Please ask for: Ms Iqraa Malik
Email: iqraa.malik@terraquest.co.uk
Telephone: 01212341390
Our Ref: A/66/21/HH
Your Ref:
Date: 9th April 2021

Application for Planning Permission for Works or Extension to a Dwelling

Development: Erection of single storey side extension and provision of 2 parking spaces following demolition of existing garage.
Location: 16 Pine Trees Close Angmering BN16 4LT

DRAWING NO	DATE	DRAWING	PROJECT
1485-01	25.02.21	SITE LOCATION AND BLOCK PLAN	16 PINE TREES CLOSE ANGMERING LITTLEHAMPTON BN16 4LT
DRAWN	SCALE		
RC	AS SHOWN @ A1

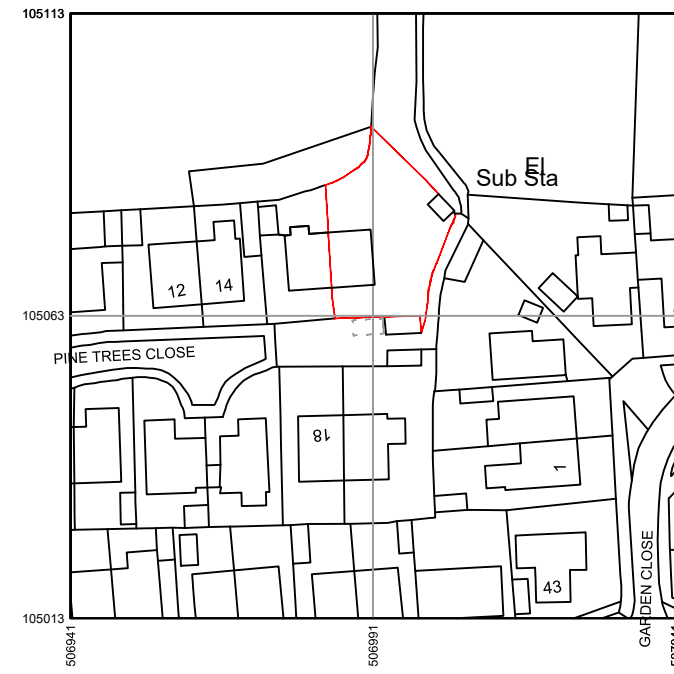
Dimensions: You are required to include dimensions on the block plan from the proposed extension to all site boundaries
